**1. General Comments on Forest Heights Properties MS 206  
from Judith von Ahlefeldt  
Adjacent Property Owner  
January 22, 2021  
FOR EDARP record, and Public Discussion**

I have reviewed in detail the Submittal Documents posted through early January on EDARP for Forest Heights Properties (variously Forest Heights Estate sor Didleau Properties), and the Initial Review comments posted through January 22, 2021 per Departments and Agencies.

8. CONCEPT PLAN & PROFILE ROADWAY

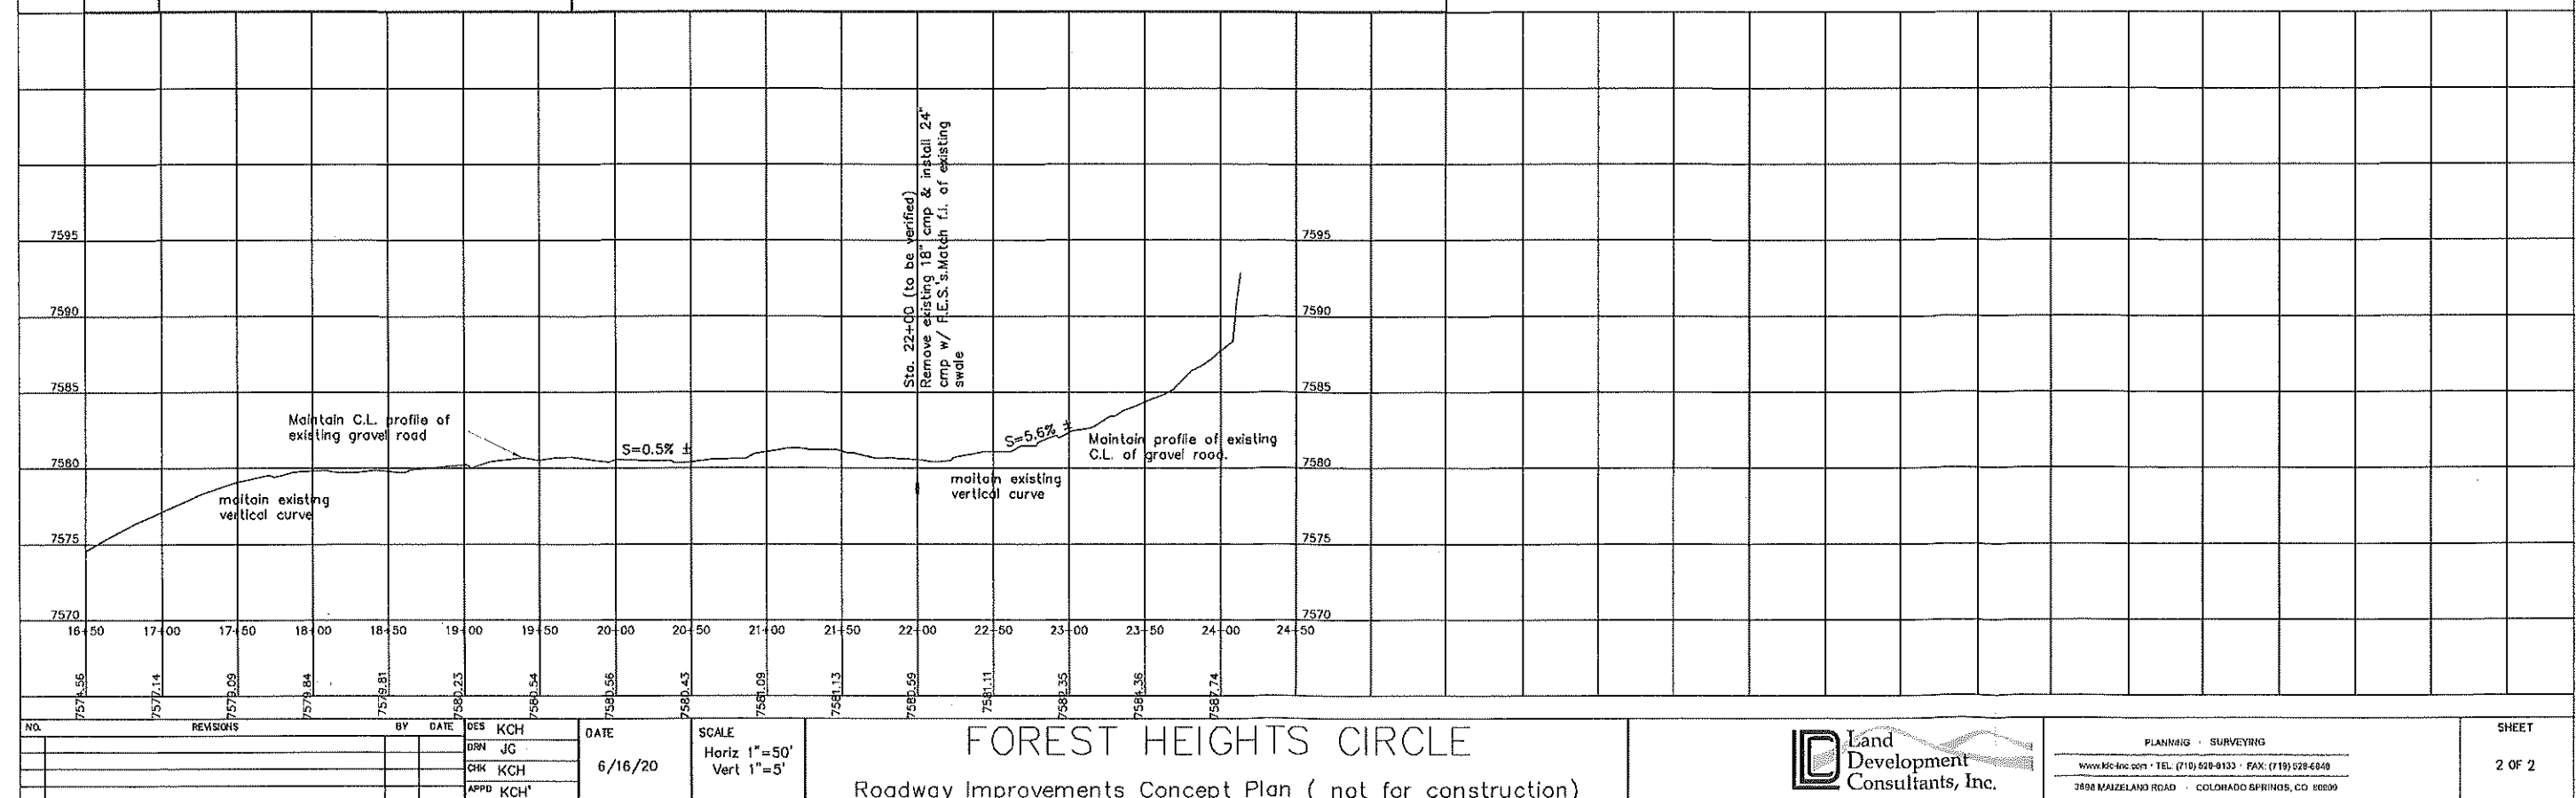
- c. the road design is not friendly to the environment and existing attributes. At the Neighbors' meeting on March 14, we all discussed how the road could be designed to avoid Mr. Yonce's

**The Submittal Road Construction/Design does not appear to respect these concerns.**

**The road is essentially straight. It does not meander.**

- d. the road design is not friendly to the wetland at the east end of the road, and culvert replacement of Culvert 1 is not necessary for either weight bearing or drainage. Many extremely heavy loads from my house demolition were hauled over that culvert, as well as 40 full end-dump truck loads of fill for my rebuild and multiple loads of cement, and equipment, log loads bound for the Westcliffe Sawmill, cement pumper trucks, crane trucks, trusses and all other manner of rebuilding materials were hauled over that culvert in addition to 50 years of garbage truck service.

I explained to LDC that replacing that culvert would require digging up my new natural gas line, and also Phyllis' phone line, and possibly removal of cottonwood trees at her driveway entrance that she had said she wanted to keep.

The Submittal Construction documents call for a 100-foot diameter cul de sac (120 feet is included with the 45' x 60' additional easement on Parcel ...081).

**I am opposed to the design of this road as submitted. There are other options.**

**I support the Alternative Road Design suggested by County Engineering.**
